320110885P

Conversion of 1no. former milking parlour to 2no. residential dwellings with associated parking and landscaping

RE: Conversion of 1no. former milking parlour to 2no. residential dwellings with associated parking and landscaping
 AT: Watts Close Farm, Gisburn

AL 1038 WATTS CLOSE FARM
(2-14) PROPOSED FLOOR PLANS, SECTIONS AND ELEVATIONS
SCALE 1:100 @ A1

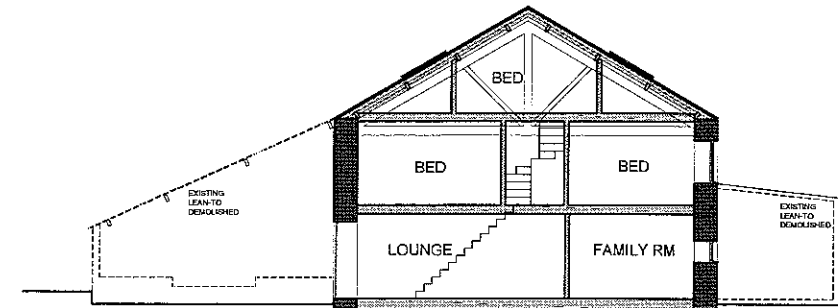
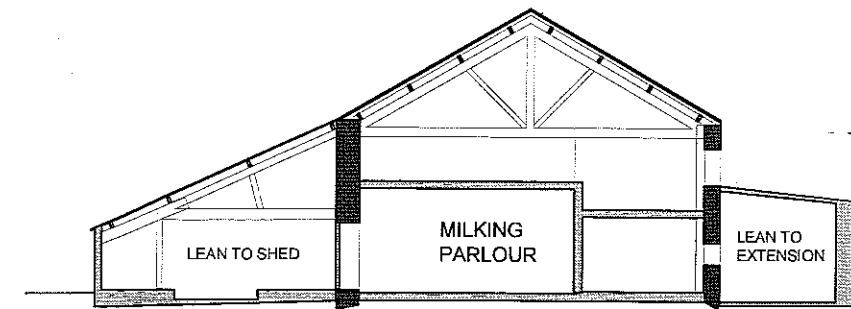
- The existing lean-to on the east elevation has only been labelled as being demolished on the proposed section. For clarity please could this also be annotated on the other plans as you have done for all the other aspects of demolition

1. Drainage Information
2. Revised elevations indicating lean-to to be demolished.
3. North elevation of existing garage
4. Heritage Statement for the Barn

EXISTING NORTH BARN ELEVATION (21)01
SCALE 1:100@A1

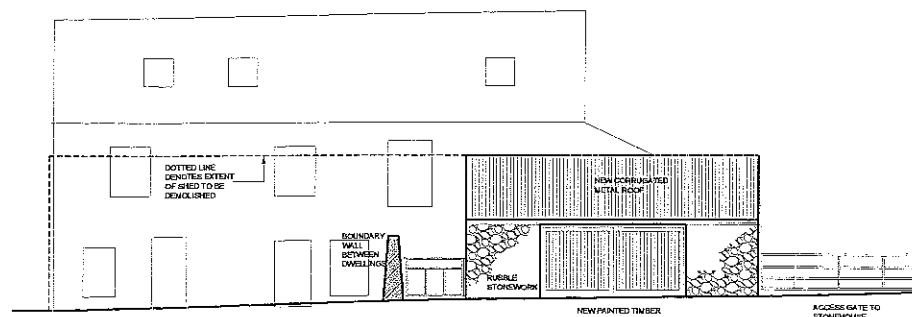
- Please can you add to the plans the existing north elevation of the barn which will be partially demolished and converted into the garage.
- Finally, please can you expand upon the information already contained in the design and access statement to provide a heritage statement. The barn is a heritage asset as defined in PPS5 (Planning Policy Statement 5: Planning for the Historic Environment). The statement should explain the significance of the buildings and explore their history and should also include justification for the proposal. Historic maps should also be included and referenced within the statement, these help with identifying the age of the buildings. Policy HE6 of PPS5 explains the information requirements for applications for consent affecting heritage assets. The following link will take you to PPS5:
<http://www.communities.gov.uk/publications/planningandbuilding/pps5>
